EP-24-0077 Monument Ridge East
N½ Section 2, T11S, R67W, 6th Meridian
39.1284, -104.8624
File Number: SP241

With this referral, we received a request to provide Review Comments (Email dated 8/29/2024), Preliminary Drainage Report (PRC Engineering, 9/5/2024), Preliminary Plan Drawings (Bear Creek Surveying, Inc., 8/12/2024), Response to Review Comments and Soil and Geology Study (Revised) (Entech Engineering, Inc., 8/7/2024), and other documents. Entech updated Figure 7 (Geology/Engineering Geology Map) to the current site plan with the geologic hazards and constraints associated with the site. Additionally, the preliminary plan has been updated to reflect Entech's study.

# MONUMENT RIDGE EAST

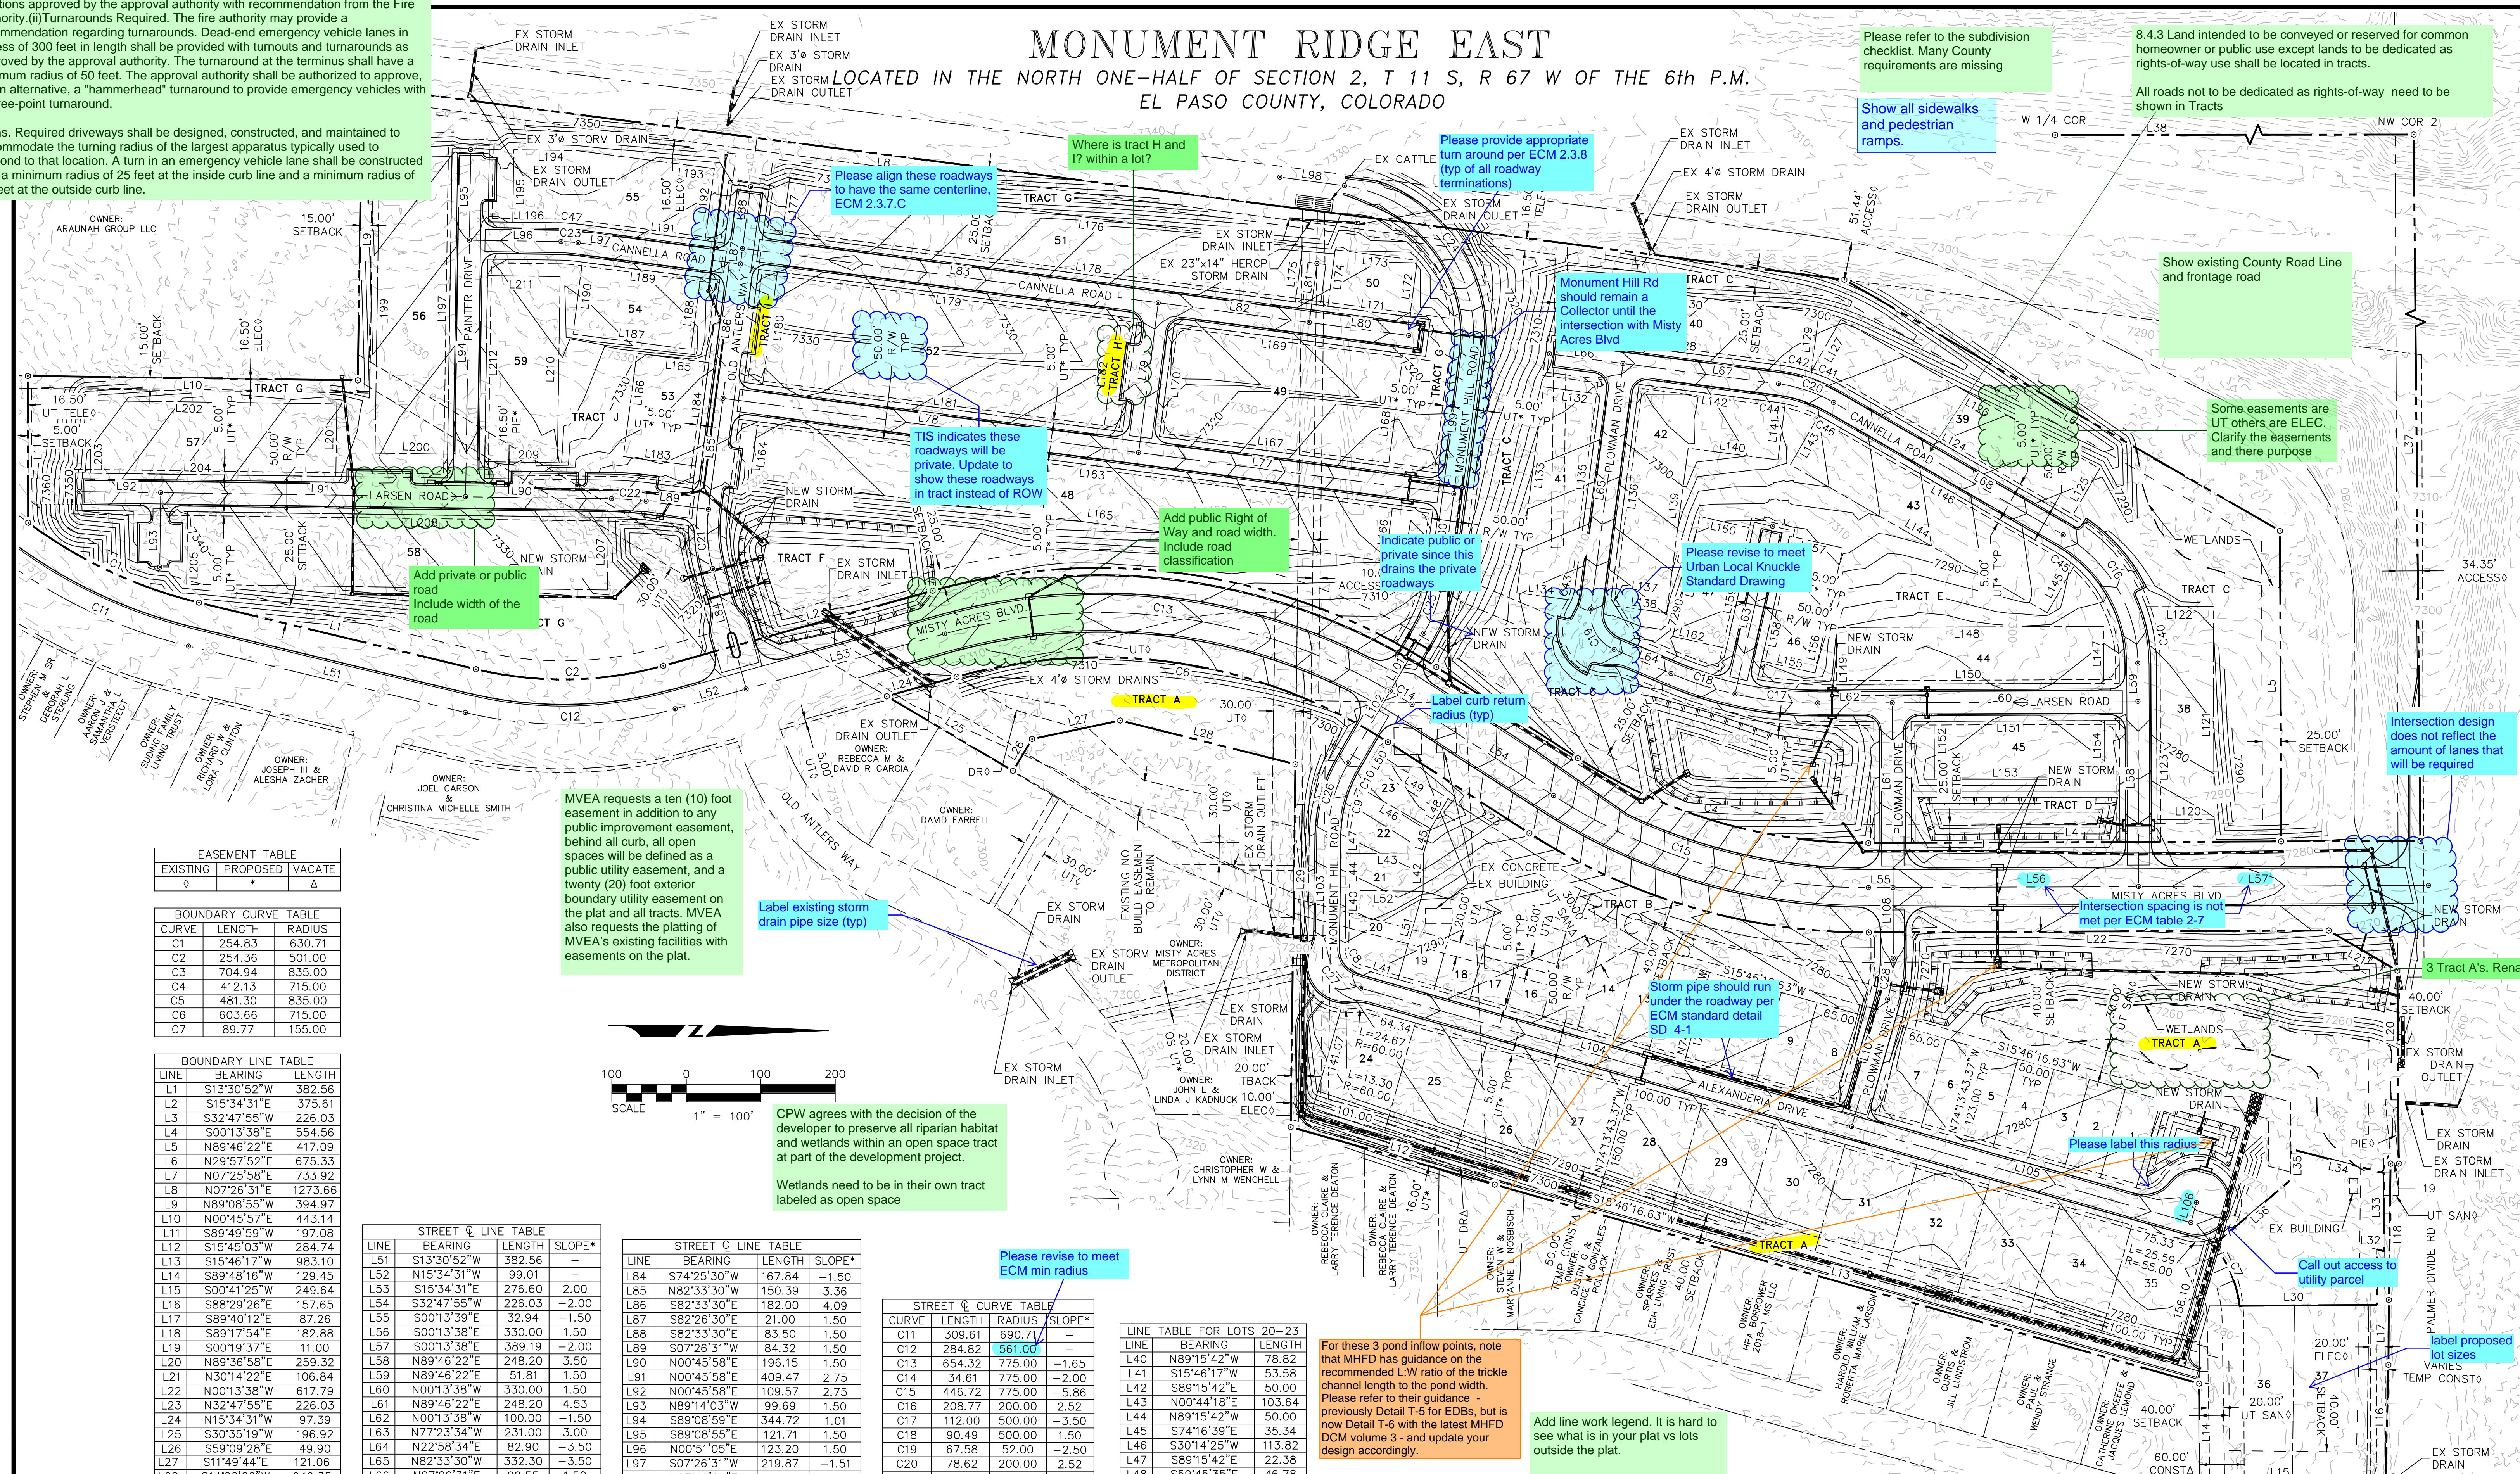
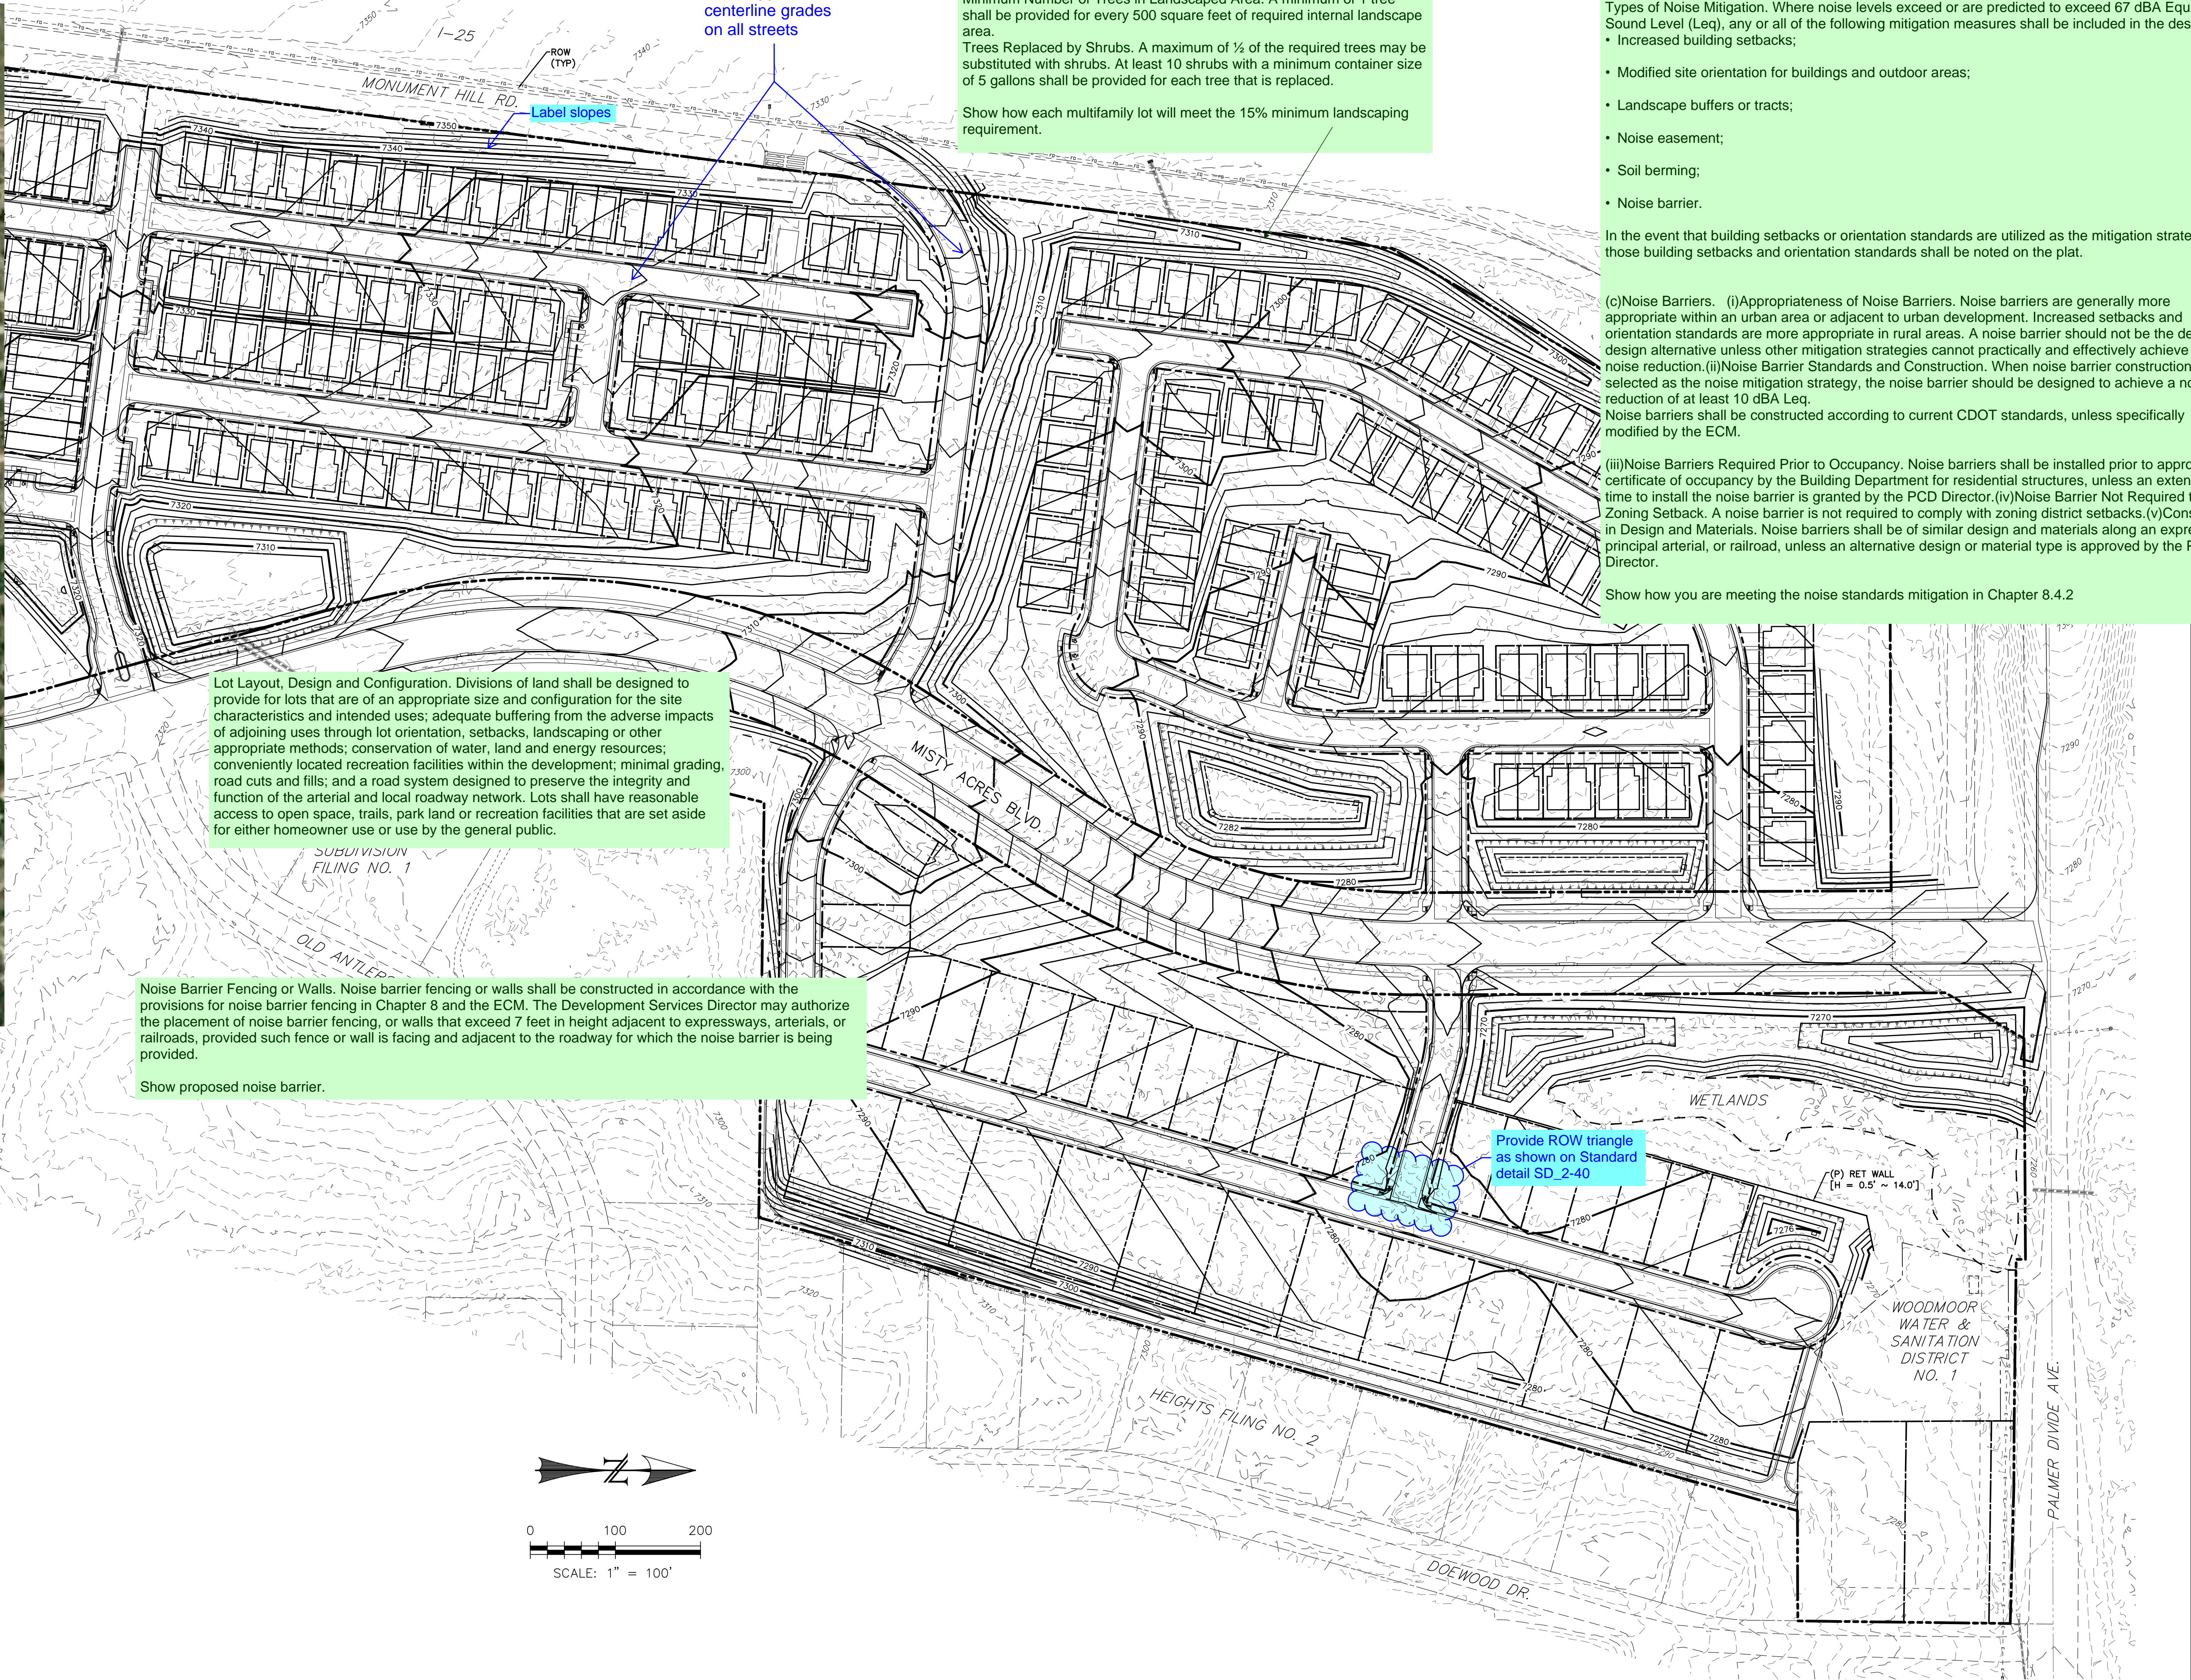
- a. CGS appreciates Entech's installation of the four monitoring wells within the site. Groundwater depths between 6 to 16.2 feet were recorded in August 2024. It is crucial that these groundwater elevations continue to be measured during Fall/Winter/Spring 2024/2025 and after early grading operations. This is necessary to determine the extent of shallow groundwater impacts on the overall development, as mandated by the El Paso County code.

- b. The groundwater depths measured in the monitoring wells appear shallower than the proposed final grades for some of the development. We agree with Entech (page 12 of their revised report) that *“Foundations should maintain a minimum separation of 3 feet between the foundation grade and the maximum anticipated groundwater level.”* If the minimum separation cannot be achieved (as determined from the continued groundwater monitoring/observation program) and mitigation measures are not possible (such as raising site grades well above maximum groundwater elevations based on a minimum yearlong monitoring program or a properly functioning area groundwater collection system (subsurface underdrain system) for the development, see Item 2.a below), then **NO basements** or other below-grade spaces (crawlspaces, walkouts, etc.) should be permitted within Monument Ridge East.

- a. CGS recommends that the preliminary plans include a statement indicating “no basements or other below-grade spaces allowed” or that mitigation measures, such as raising the site grades, be incorporated. We understand that site-wide drainage improvements are being considered for this development. An area groundwater collection system (subsurface underdrain system) must gravity discharge into an inlet structure or detention pond without any possibility of back flow or blockage. Subsurface underdrain systems should be designed in accordance with the El Paso County Engineering Criterial Manual (C.6.2.E) and shown on the plans.

3. Wetlands (Freshwater Emergent/Freshwater Forested/Shrub Wetland) are located within the site. Setbacks and “no build” areas should be noted on the plans.
